Our reference: R/2021/10/A

Your reference: SSD 32927319

Subject: Advice on EIS - Powerhouse Ultimo Renewal - Stage 1 - SSD 32927319

Figure 11.17 Turbine Hall Grading of Significance (Basement) NB: Exceptional component shown in this figure is the Water Cooling System and Manifold pump, assessed separately in the relevant section below of Part C (Source: John Wardle Architects plan with Curio Projects overlay)

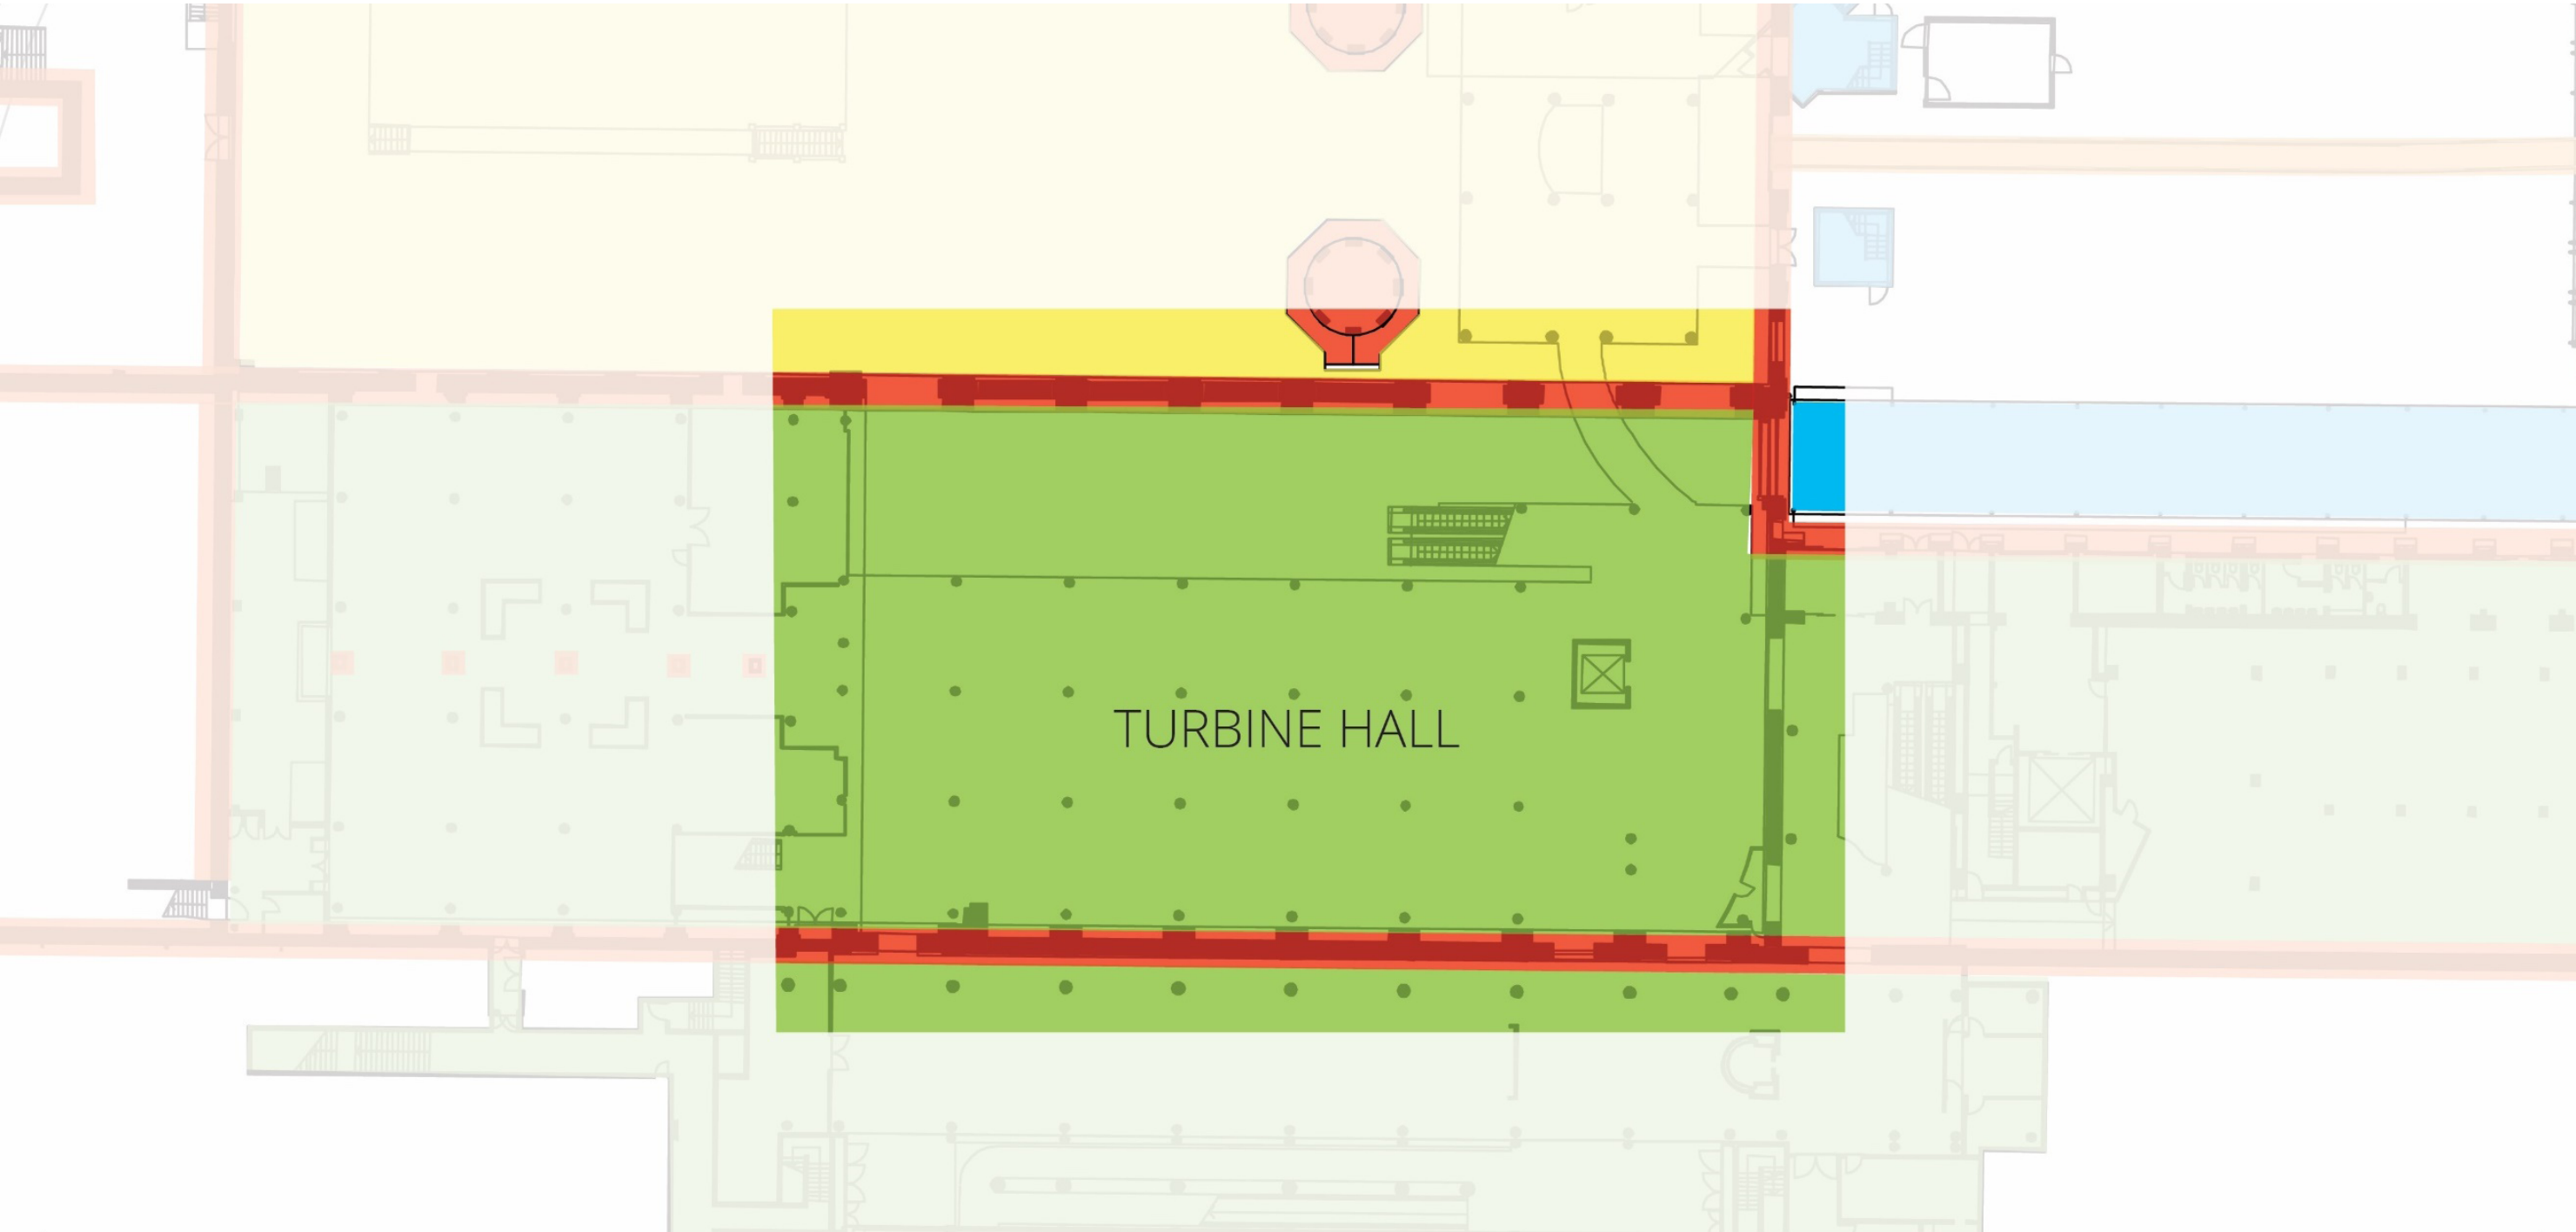
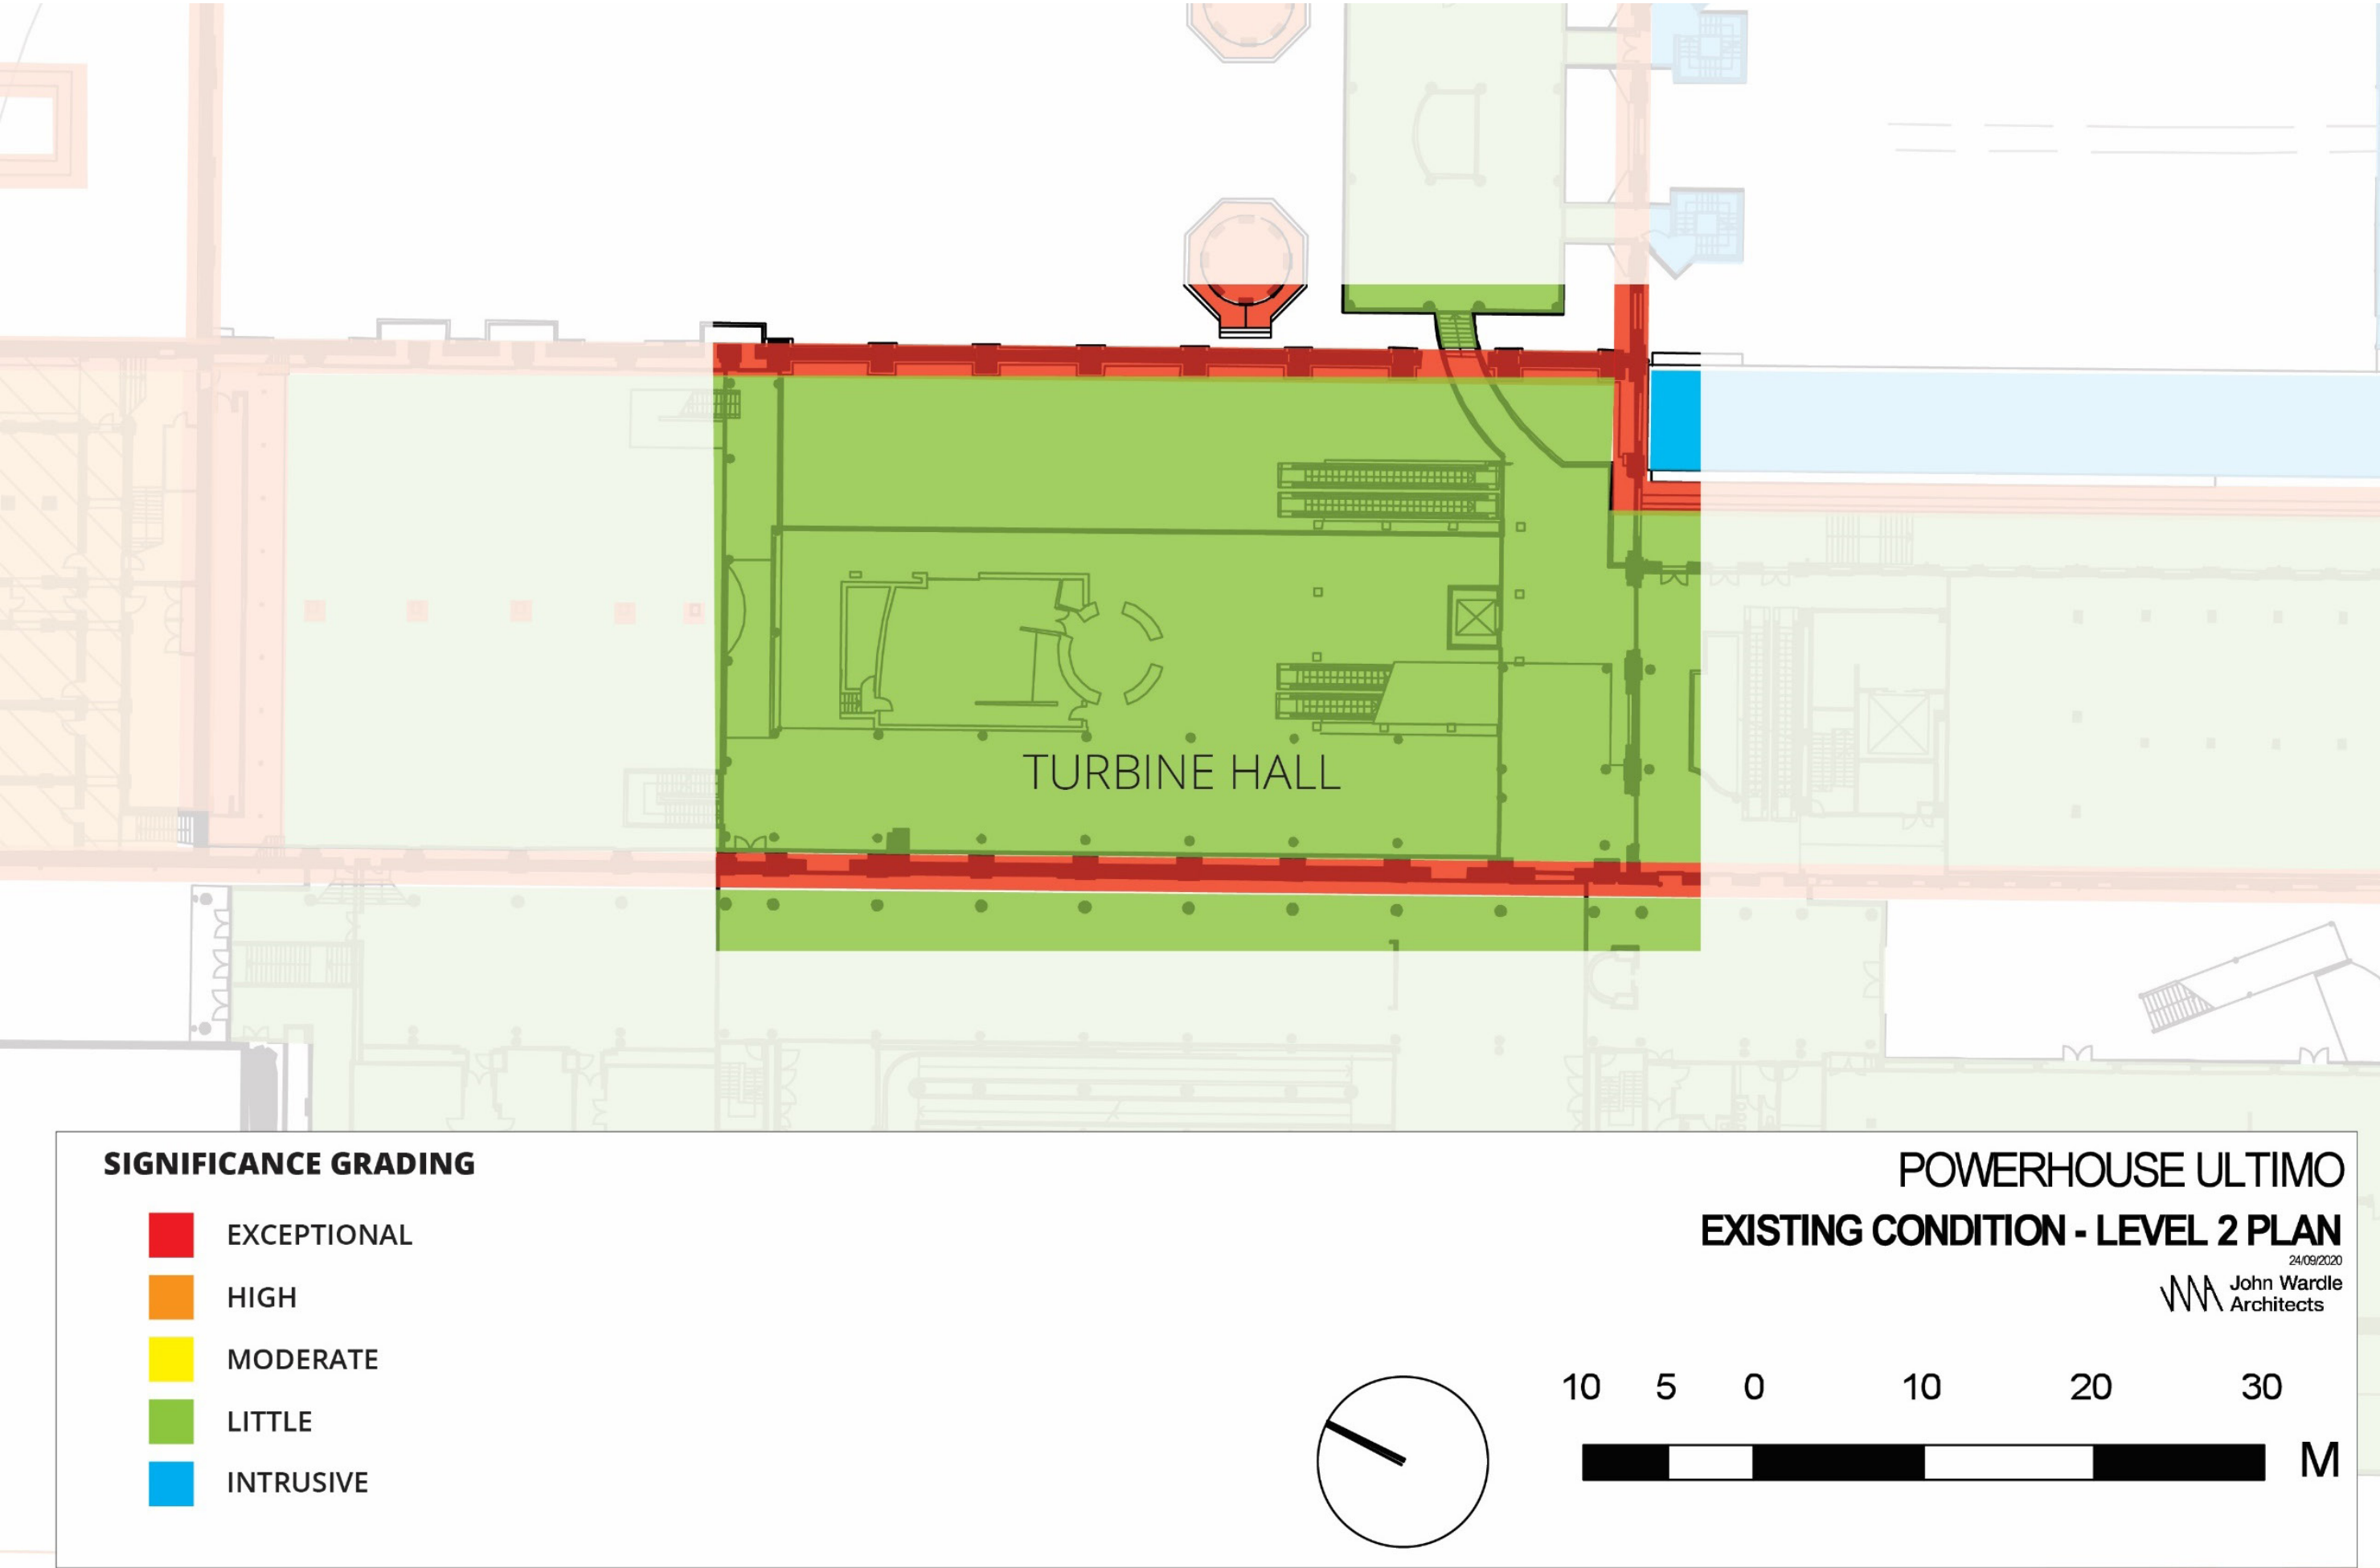
- Section 4.4 Heritage curtilage and Section 4.5 do not comprise a sufficient curtilage analysis.
- Sections 4.6 Gradings of significance – The plans representing the gradings in Part C should be consolidated into Part 4.6, as one single detailed plan of the site. The plans in Part C are too large to be legible. At present the plans in part C are too fragmented to be readily located. The grading of significance should evaluate the buildings in 3 dimensions, represented in sections and elevations of the buildings to pick up elevation detail, roof forms, internal structural elements, fabric and components such as gantries. The roof plans should identify all the distinctive roof forms such as lanterns and chimneys.
